# **Suffolk County Council (20031377)**

Response by Suffolk County Council to Action Point No. 7  
Consequent Upon ISH4 on Environmental Matters and the draft  
Development Consent Order (dDCO)

## **Sunnica Energy Farm (EN010106)**

**3 March 2023**

### **I.1                      Works Plans**

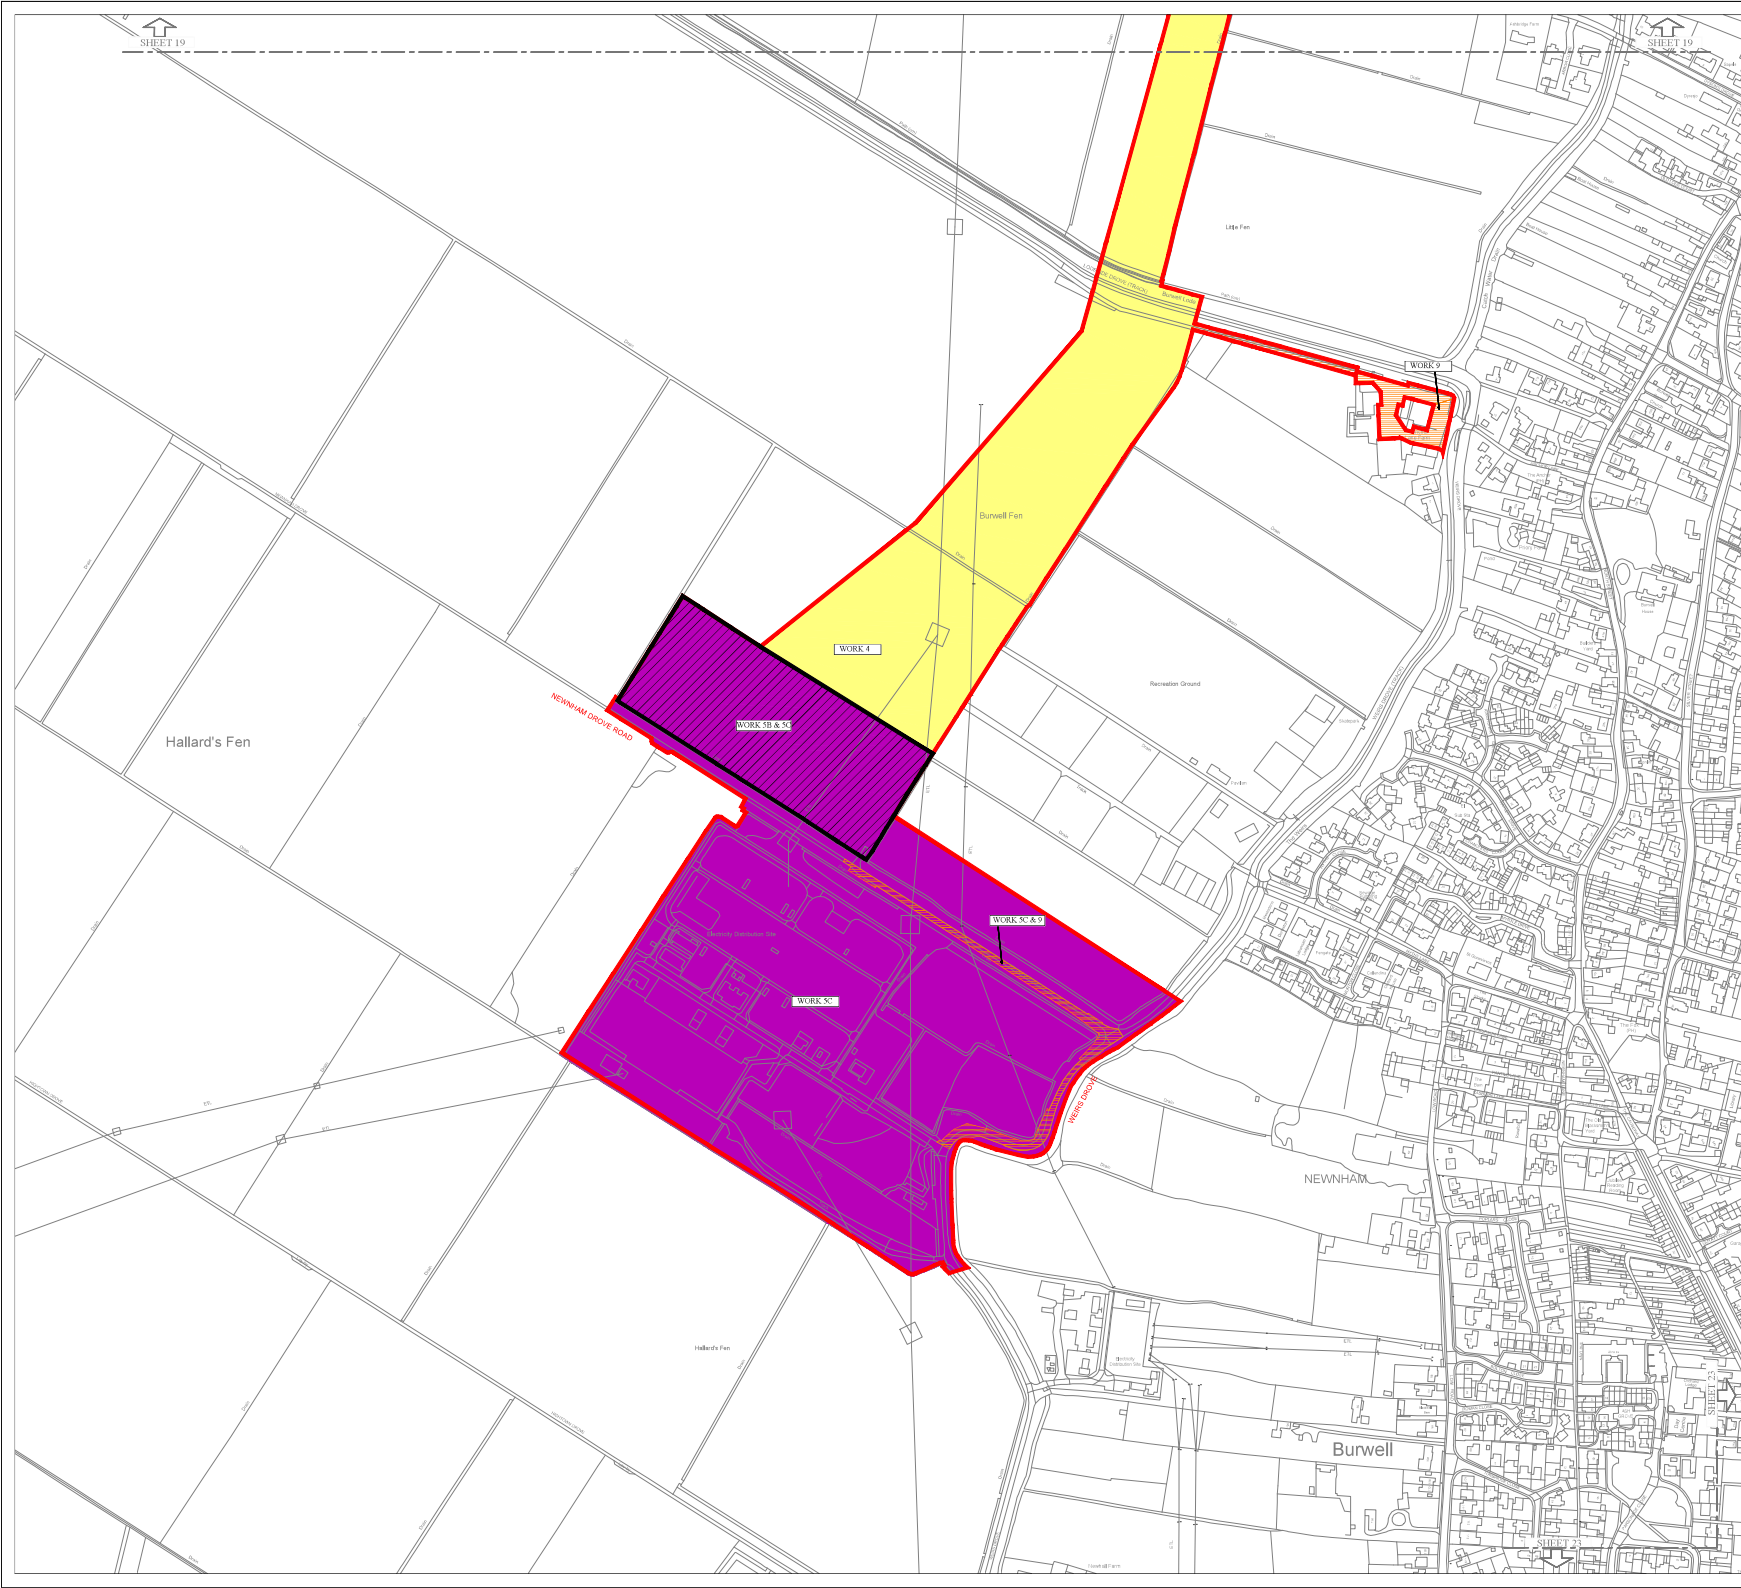
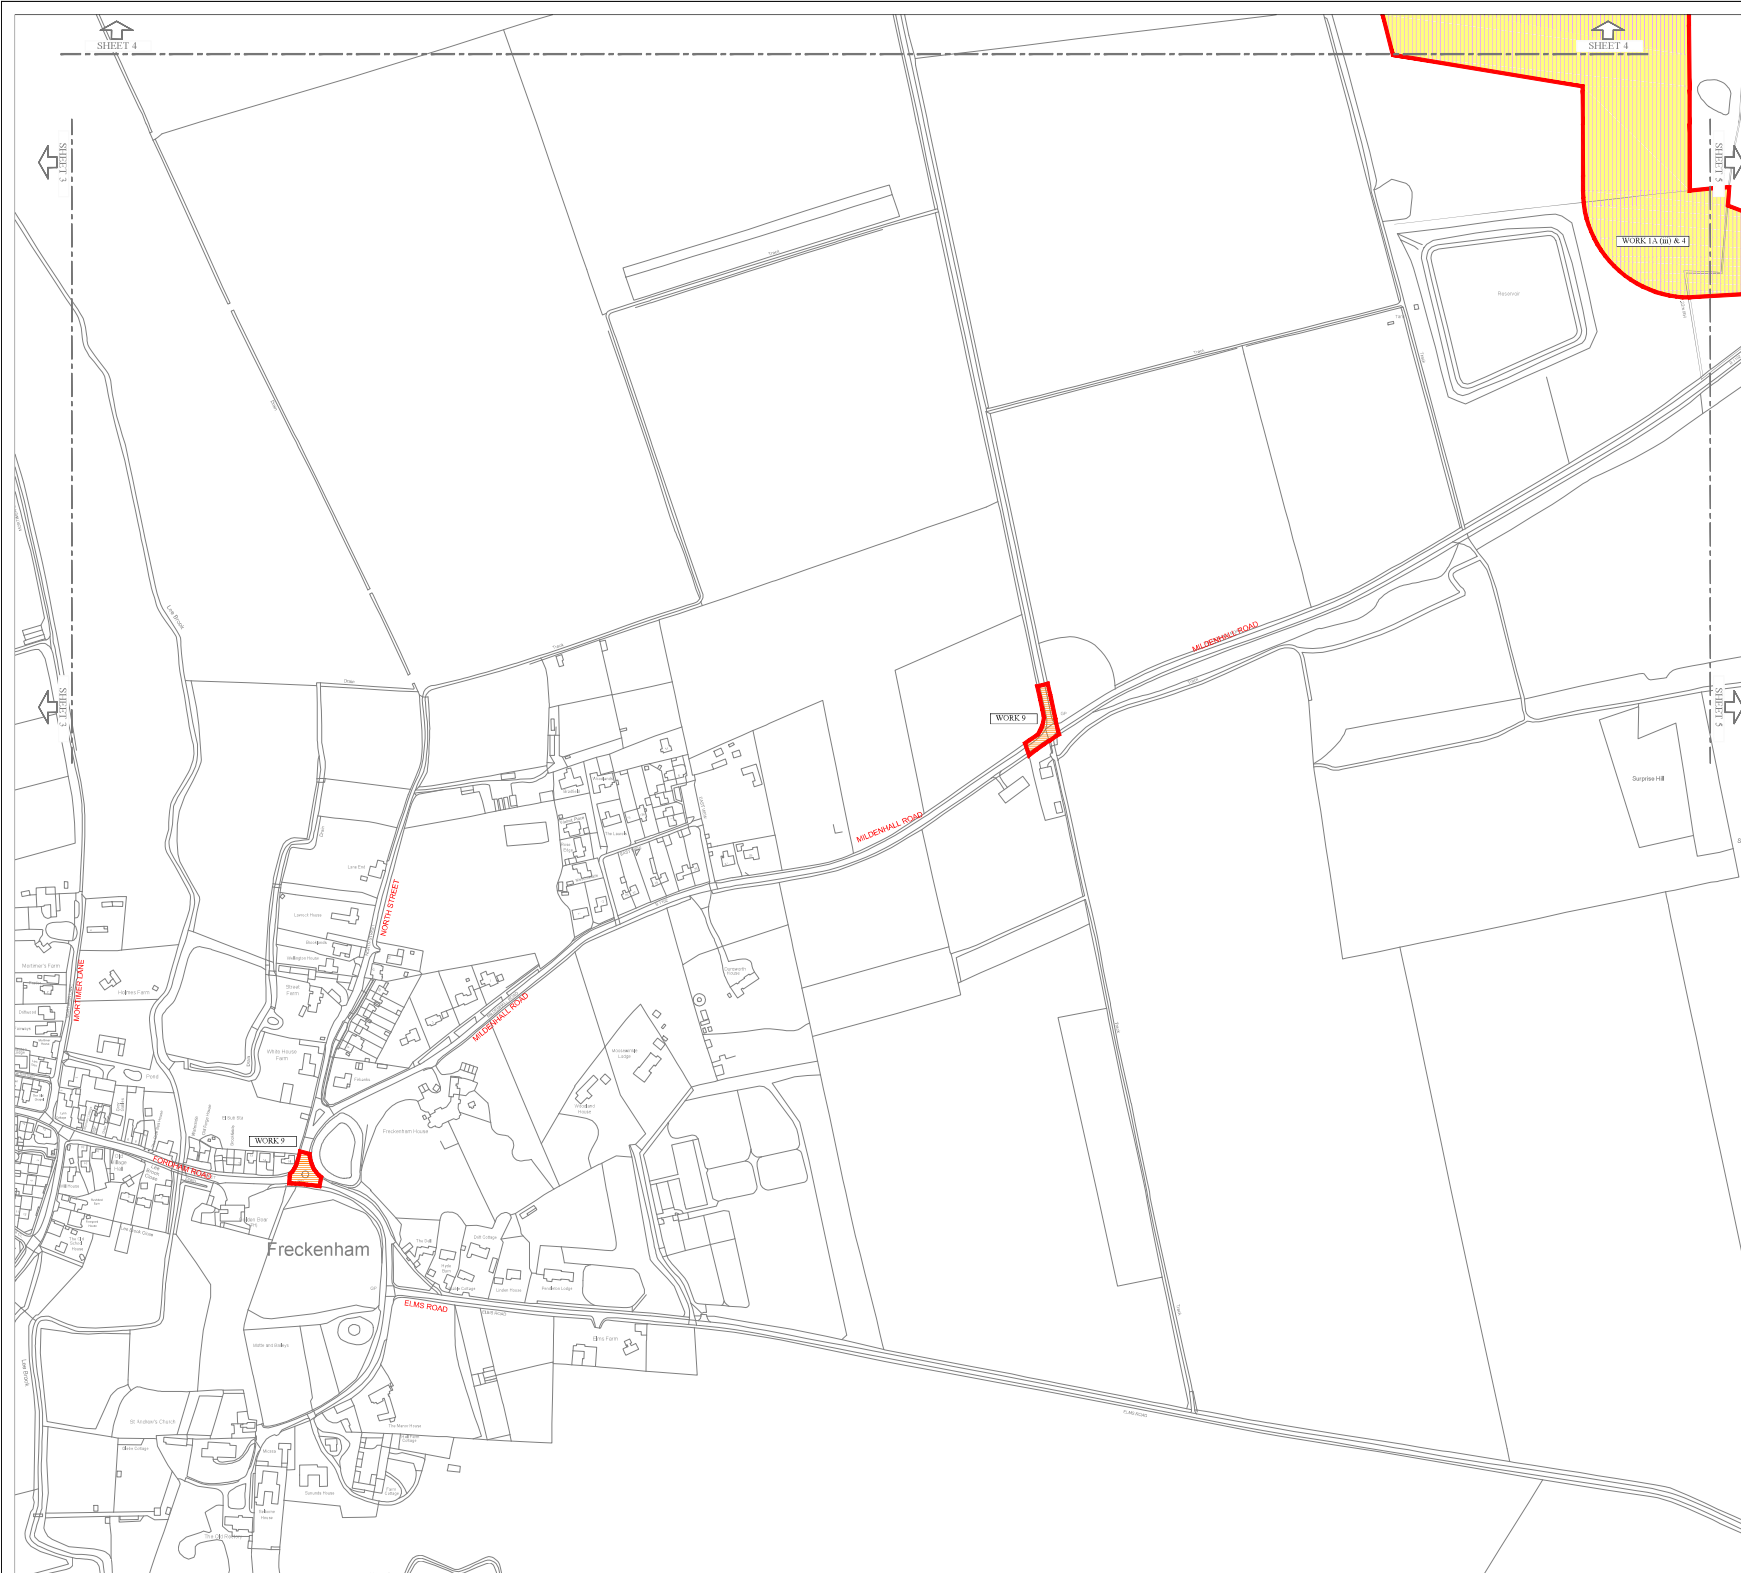
11. It should be noted that Land Parcel 5-03, which would be subject to the revisions to Work No. 1B proposed by SCC, is more extensive than Parcel E12 because it also includes Parcel EC03. In Work No. 1B only the work in sub-paragraph (a)(iii) is proposed in Parcel EC03 (as shown on Sheet 5 of the Works Plans in REP6-006), and the revisions proposed by SCC do not seek to preclude that work (electrical cables) from being carried out because it is not above ground infrastructure. There is no need, therefore, to distinguish between Parcels E12 and EC03 for the purpose of the amendments that SCC proposes to Work No. 1B.
